Application No: BE/87/21/OUT

Site Address: Nursery Fields Land to the North of Chalcraft Lane West Bersted PO21 5TS

Description of works: Outline application with all matters, except for site access, reserved for the development of up to 225 residential units with associated infrastructure, open space and vehicular and pedestrian access (resubmission following BE/148/20/OUT). This application affects a Public Right of Way.

Thank you for your internet representation made on 12th July 2021 which has been recorded as no objection with the comments as follows:

APPENDIX 3
LAND USE AND ACCESS PARAMETERS PLAN (REF:
01304_PP_01_P4)

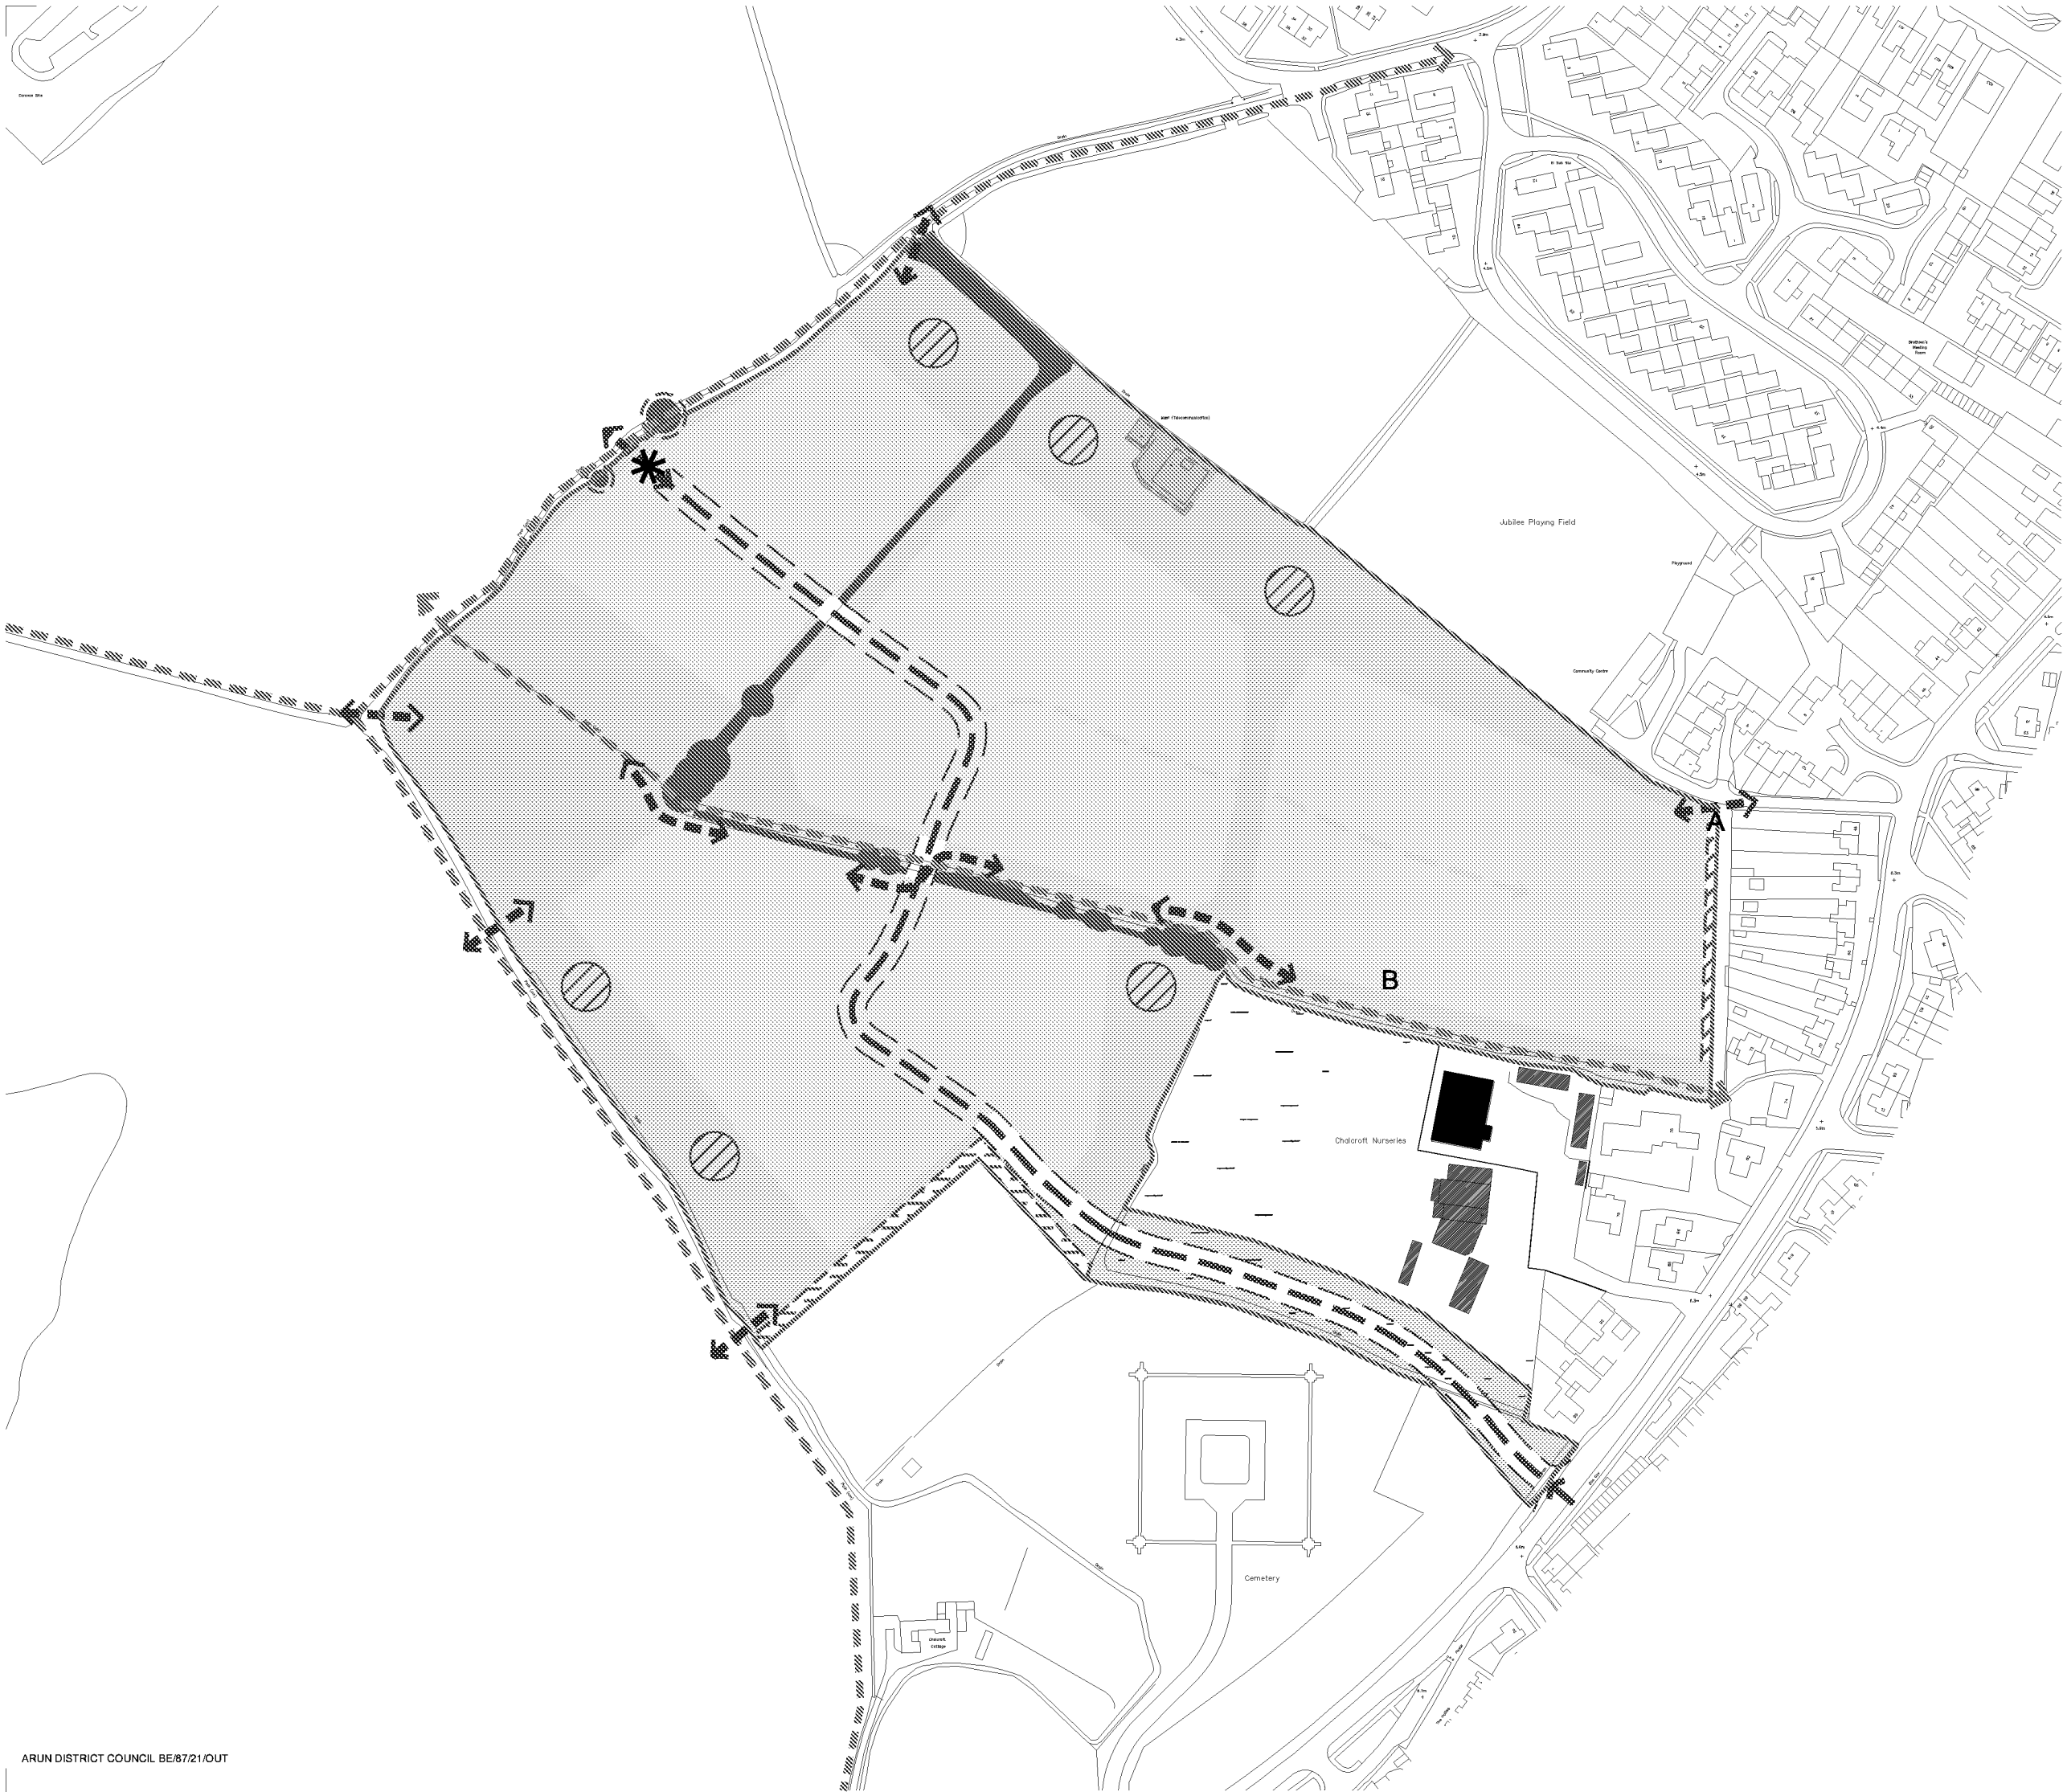
- The Green Infrastructure Parameter Plan describes the proposed layout of the primary route with cycle/pedestrian access only to the wider West Bersted site. Clarity on the likelihood & type of vehicular connection should be provided.

APPENDIX 5
SITE ACCESS PLAN (REF: ITB14244-GA-009B)

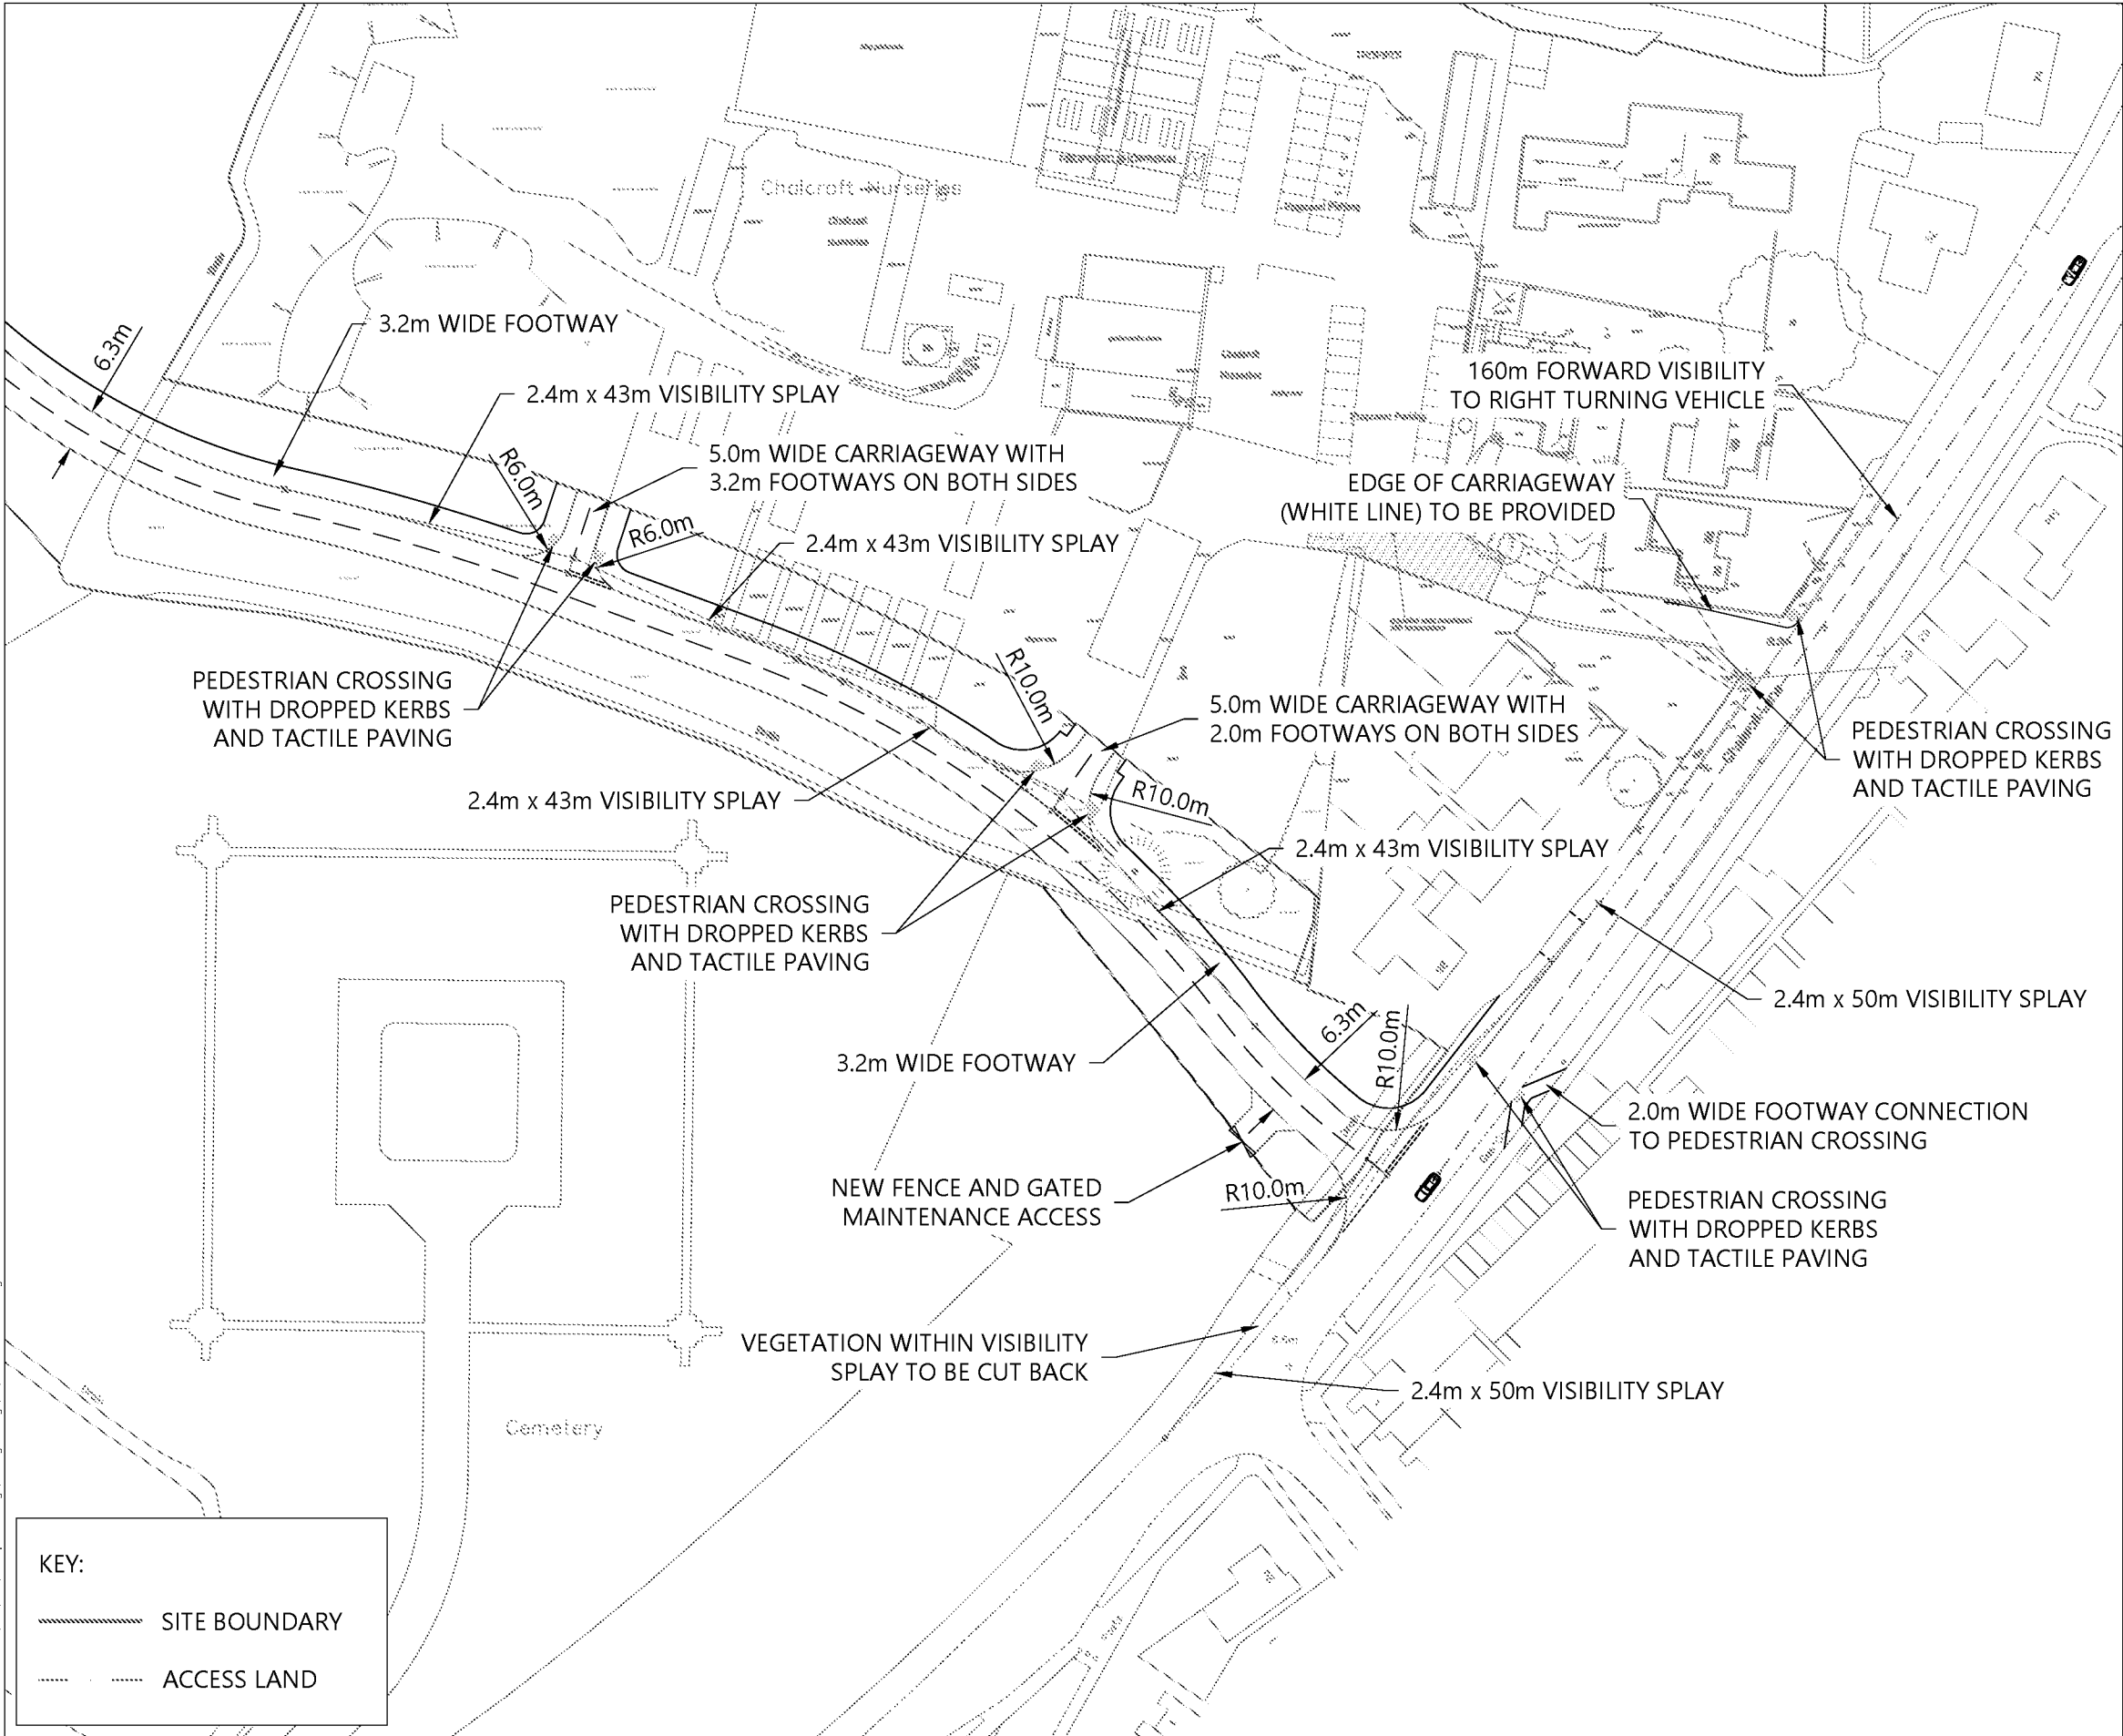
- The proposed access from Chalcraft Lane, shared with the application Chalcraft Nursery site BE/18/20/OUT, as a simple junction with no signal controls, is consistent with the West Bersted Framework Masterplan. Clarity is given in the Transport Assessment (TA) that traffic data collected in 2018 has been subject to an allowance for growth associated with committed development totalling 1,214 dwellings and 1,542 sqm of commercial development. Additionally, the TA states that whilst bus links and/or emergency vehicle access might be a future consideration for cross boundary connection, the proposed access has been designed to accommodate only the assessed vehicle numbers associated with the Nursery Fields application and that of Chalcraft Nursery BE/81/20/OUT.

- The Board notes the provision of pedestrian and cycle ways running parallel to the proposed access road.

- Given that the proposed access road is shared across two sites, the Board would encourage the applicant to work with the local planning authority and potential developers to ensure that the needs of pedestrians and cyclists are considered in the phasing of the construction cycle.
- The Board would encourage the early prioritisation of the proposed Toucan crossing installation to enable safer use of existing pedestrian and cycleways along Chalcraft Lane during the construction phase.
- Use of local suppliers and tradespeople should be strongly encouraged and in support, preferred routes to site should be identified and agreed as a condition of approval to minimise the impact on local residents and the local road network.
